The Member Secretary,
Chennai Metropolitan
Development Authority,
No.1, Gandhi Irwin Road,
CHENNAI -600 008

Letter No. **CL/39069/2000**

Sub: CMDA - Planning permission -
Additional construction of Free
Choultry building in S.No.45 of
Thiruverkkadu village for Arulmigu
Devi Karumari Amman Thiru koiil -
Development charges and other charges
to be remitted - Regarding.

CMDA 'C' / PP No. 1  
 C. No. C4/39069/2000  
 Asst. CONSTRUCTION OF FREE  
 Serutiny: CHOULTRY BUILDING AT  
 PART I 19/7/2001 SURVEY NO 45 belongs to  
 PART II ARULMIGU DEVI KARUMARI-  
 AMMAN THIRUKOIL AT THERODUM  
 VEETHI, THIRUVERKADU VILLAGE,  
 THIRUVALLUR DISTRICT.  
 D.P.

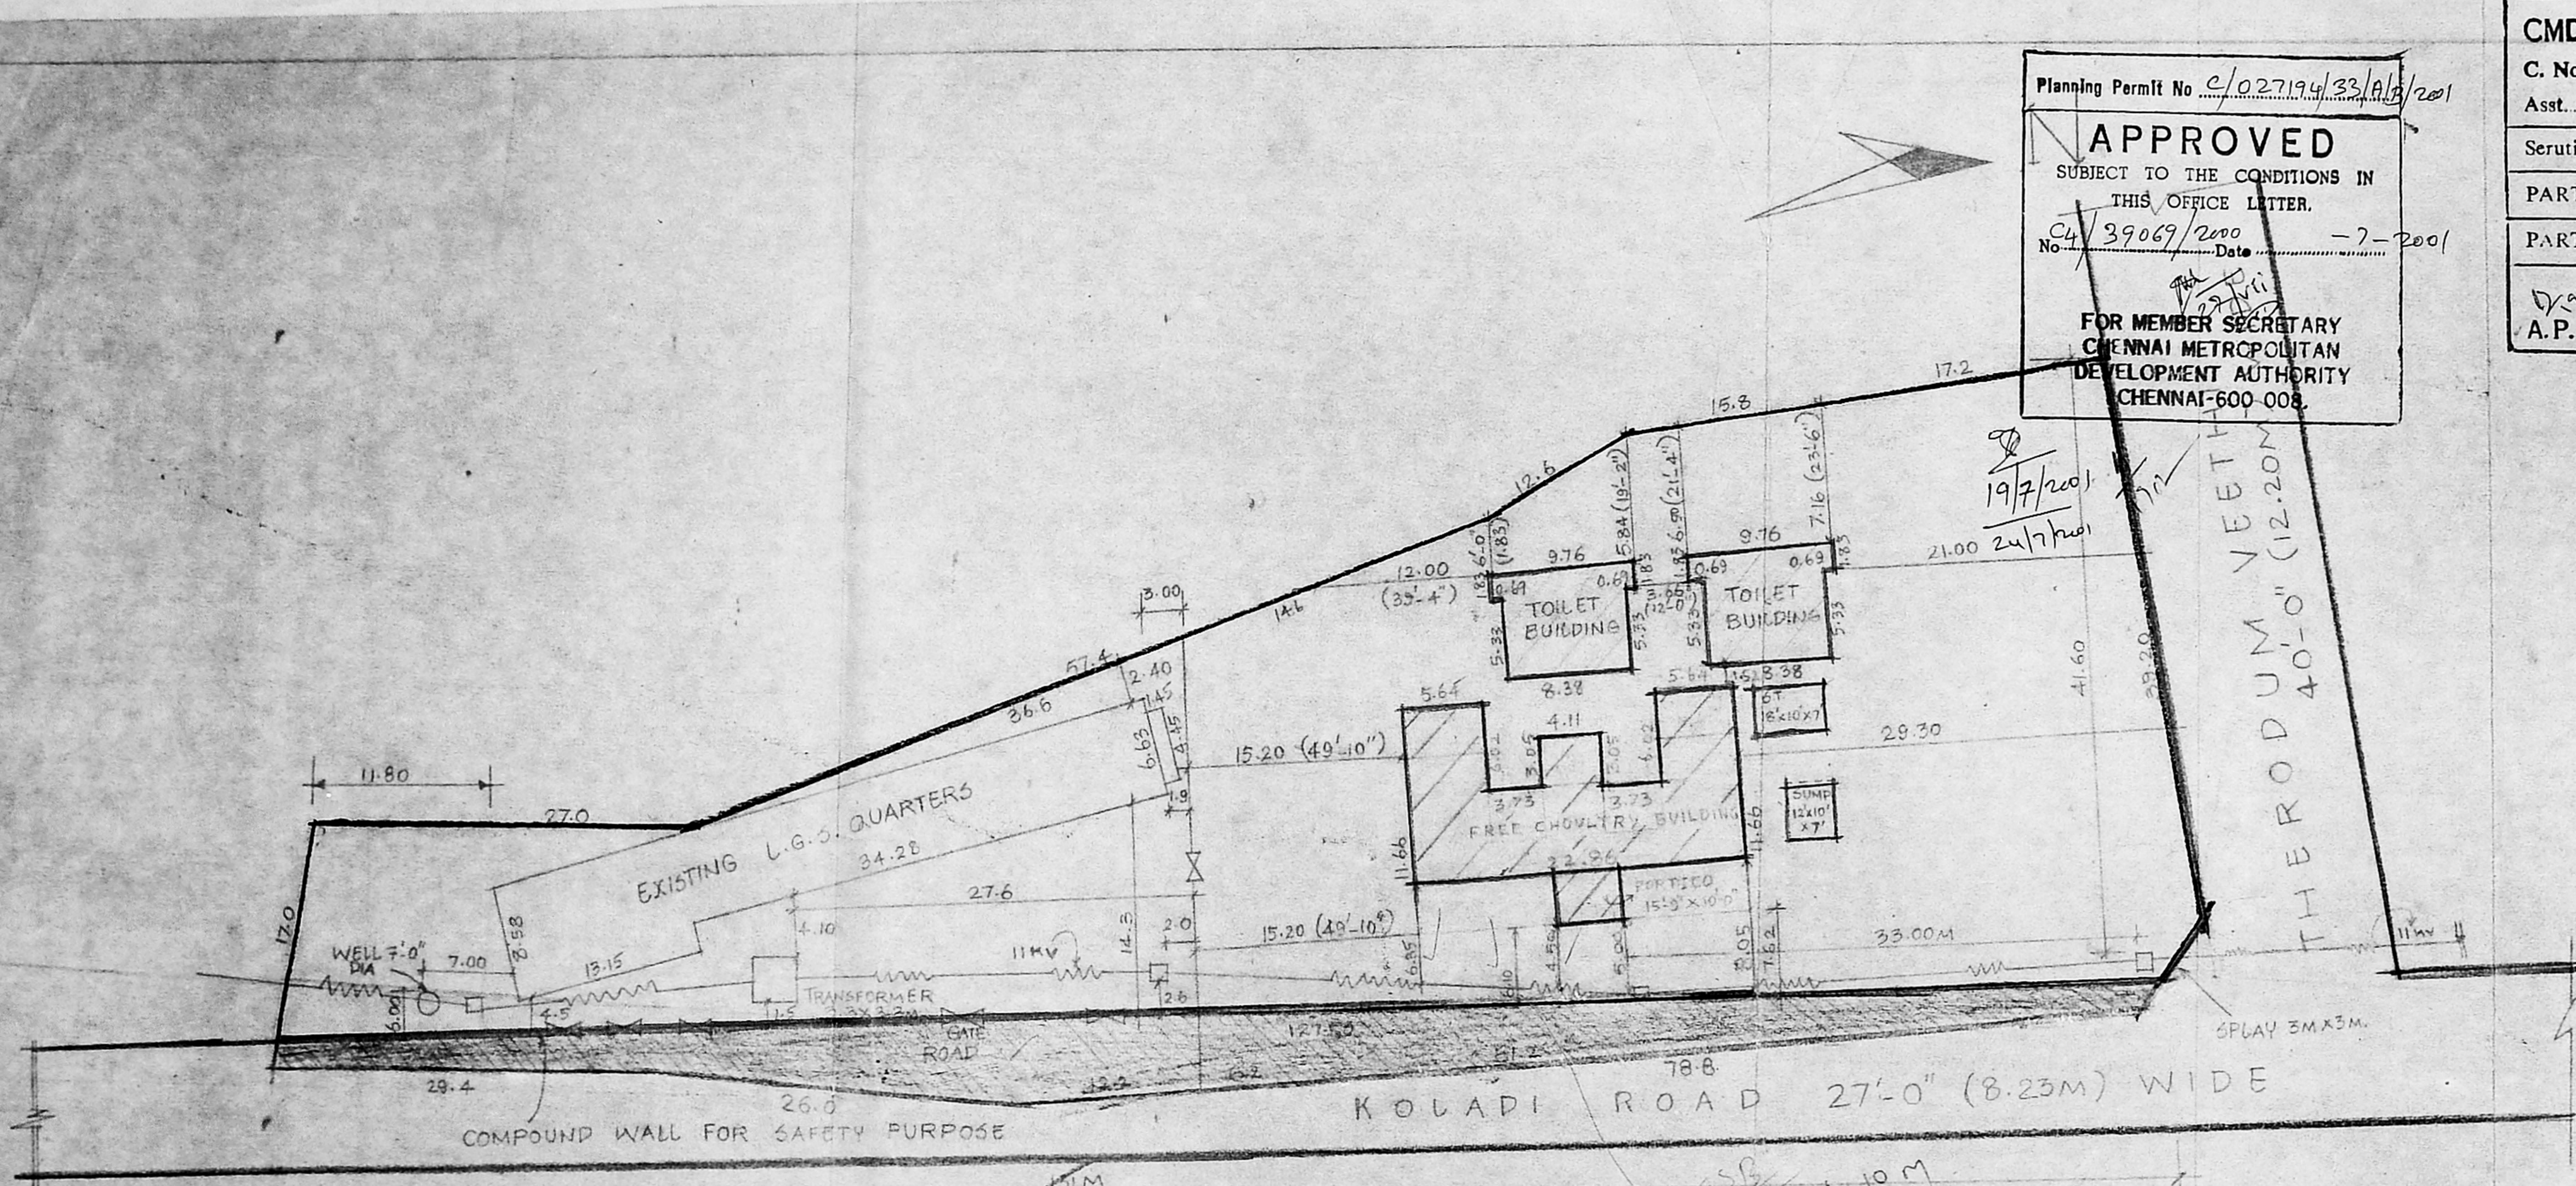
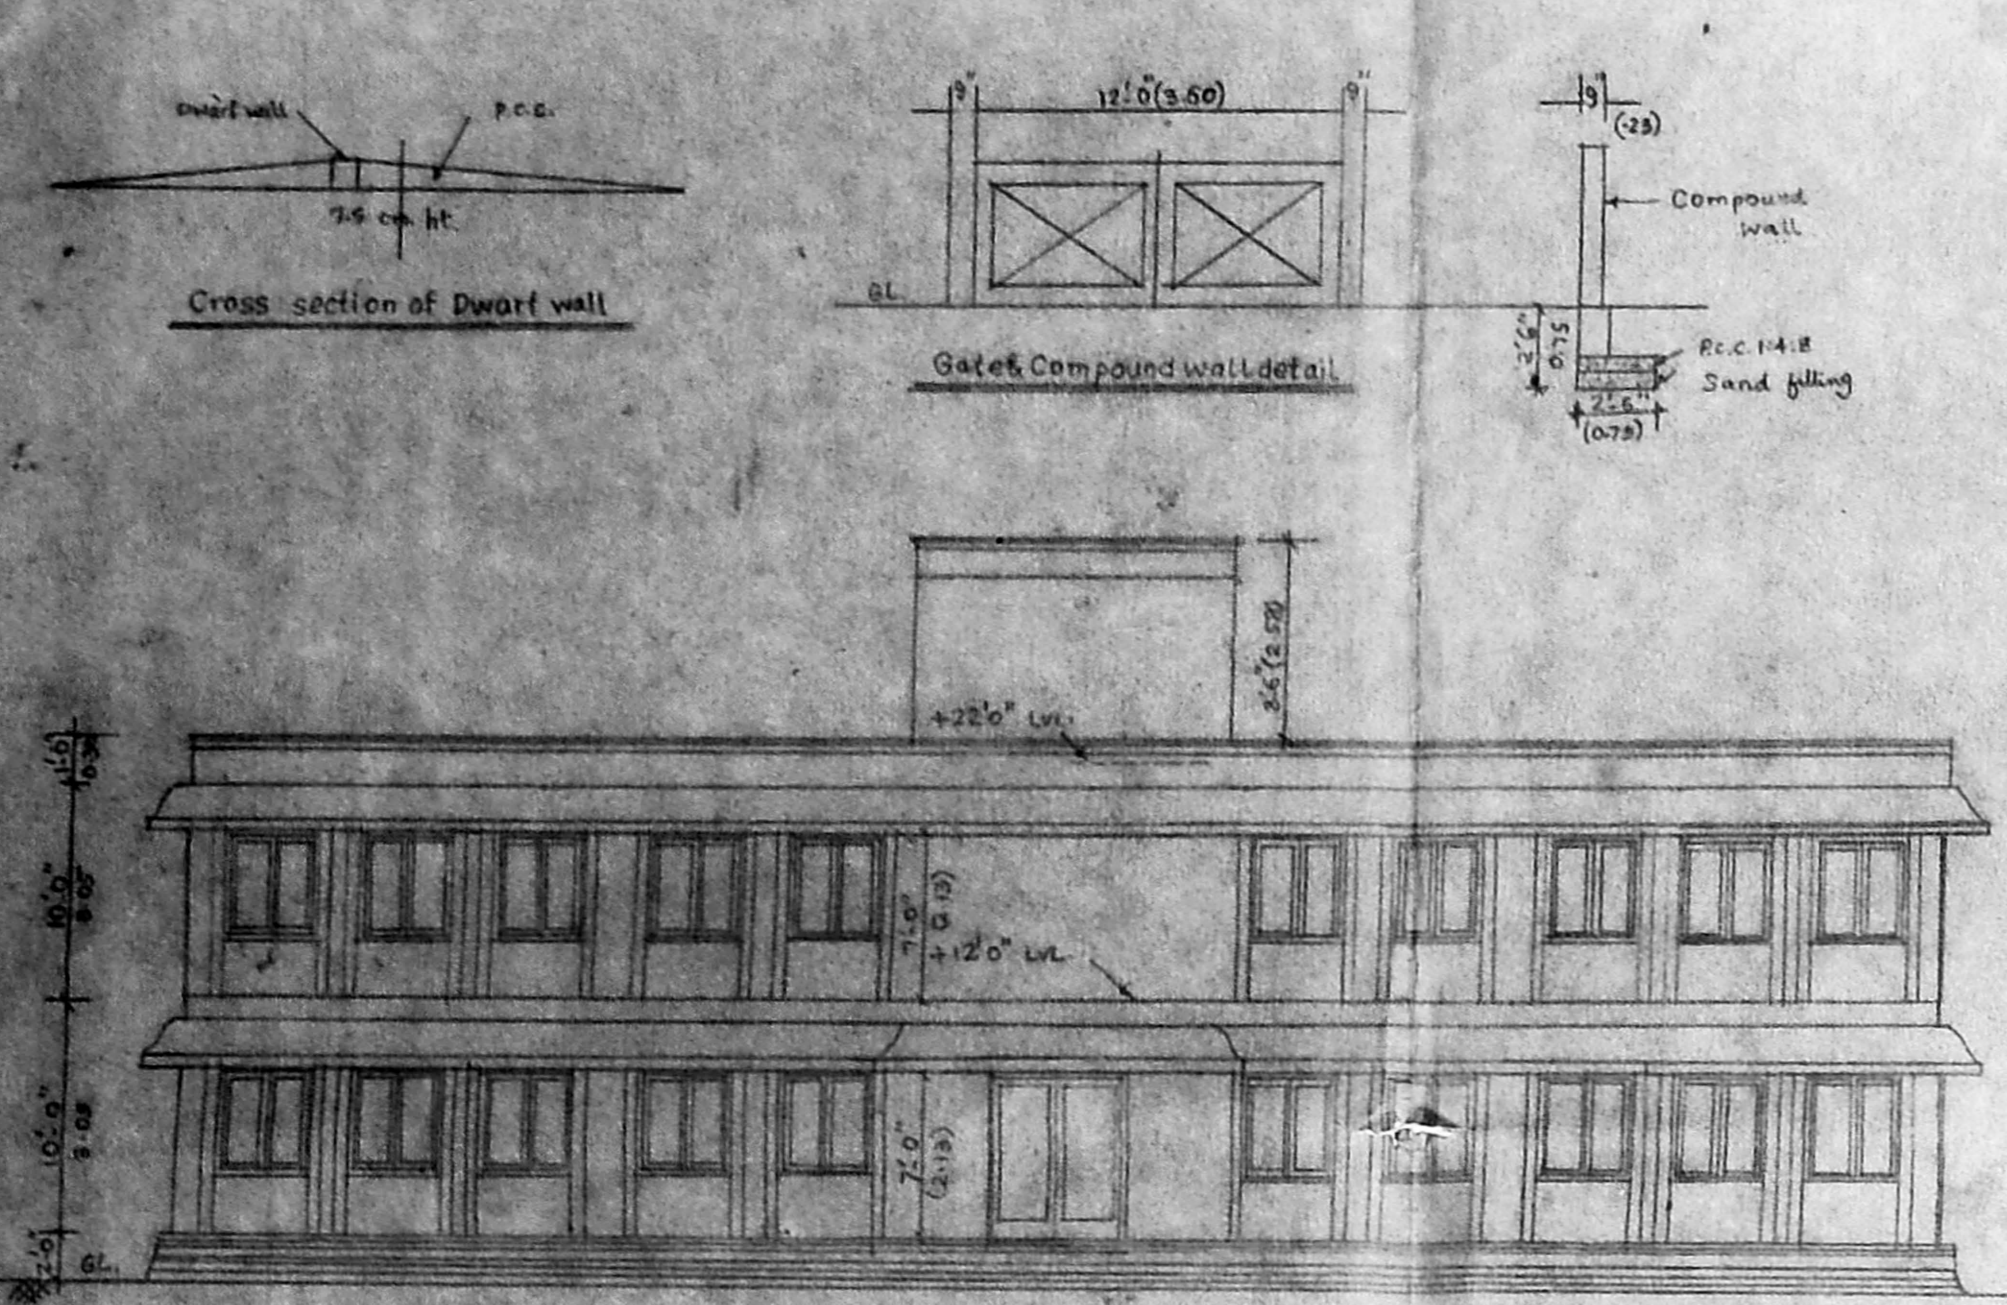
b) Revised site plan showing:

i) The location of sump and septic tank
ii) Road portions on eastern side clearly indicated by hatching

iii) Splay measurement 3.0m x 3.0m should be provided on north-eastern corner.
